Subject: FW: Proposed Development 70A Tarrant Street Arundel BN18 9DN Reference No. AB/118/20/PL

I am writing to object to the above Proposed Development as below:

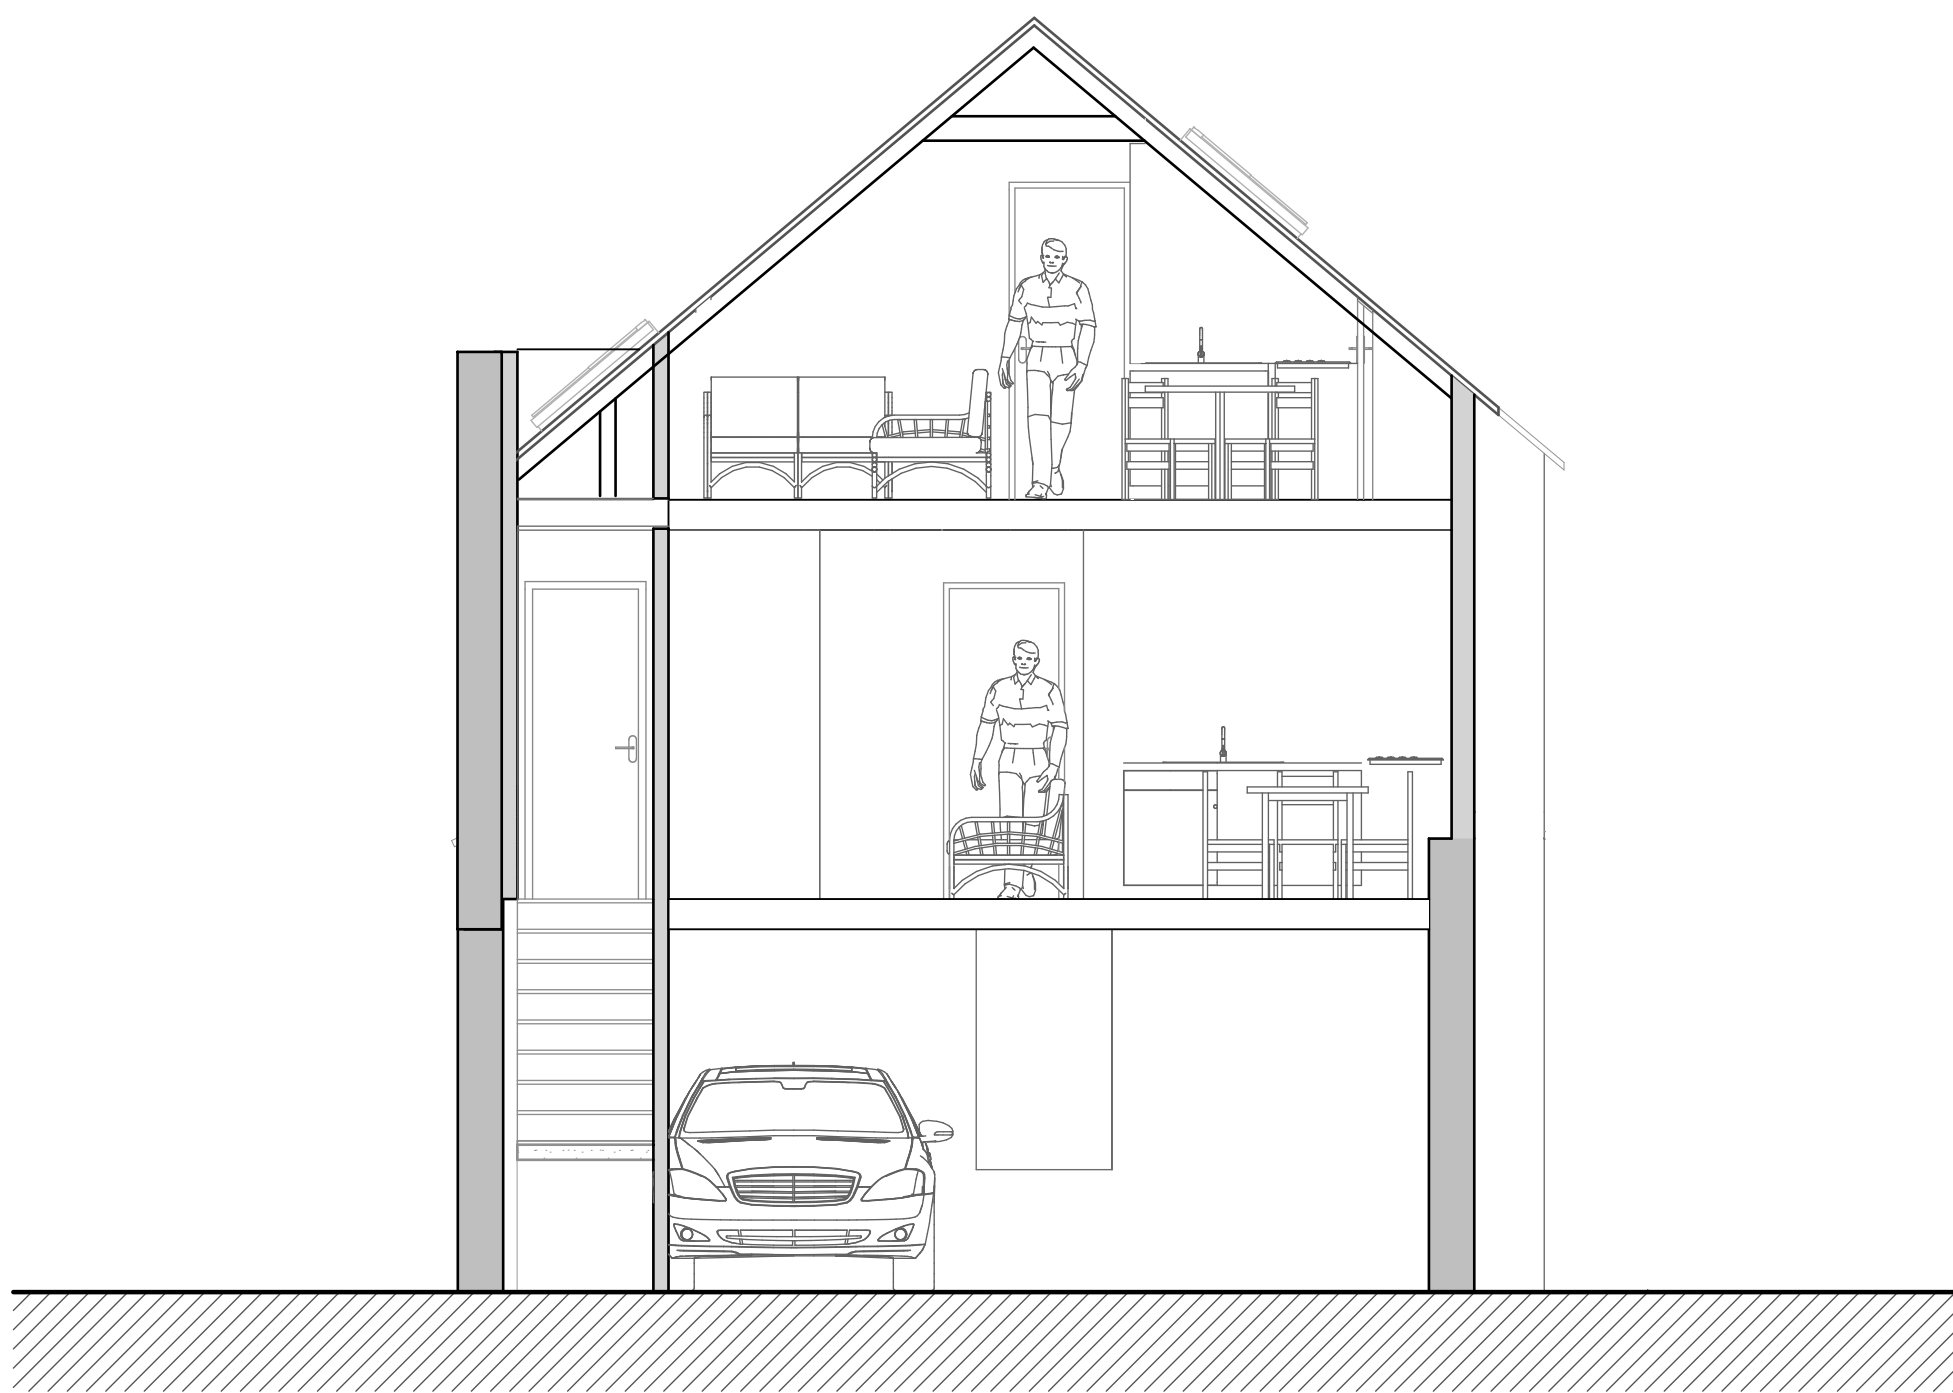
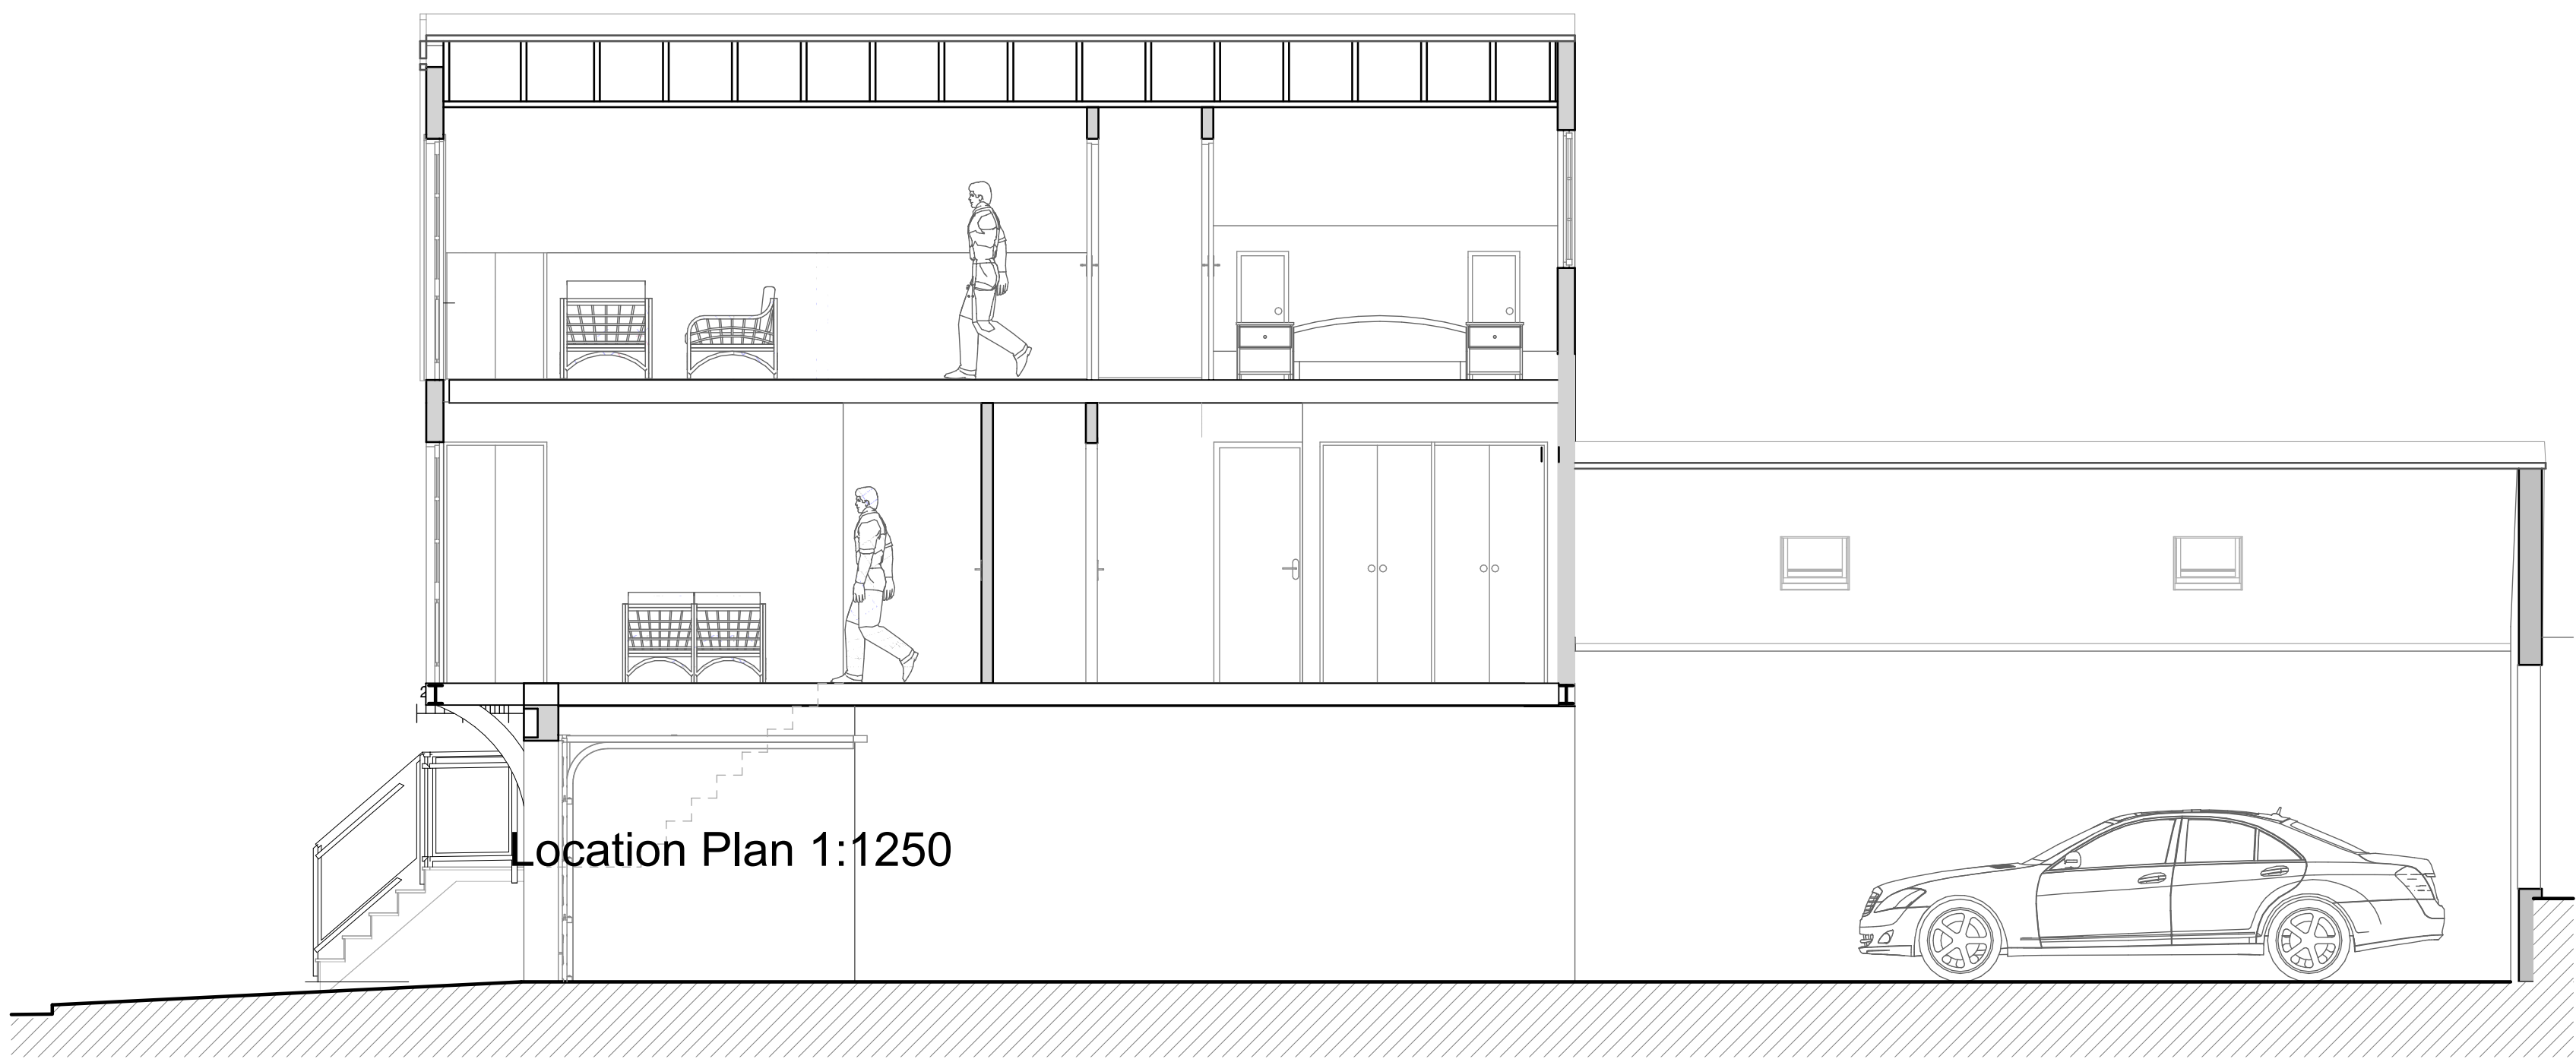
c) There is no west elevation of the new main roof shown on the plans whilst section A of 181390/04 appears to show in section only what may be a single roof light or many roof lights which will overlook Number 70 and its neighbours.
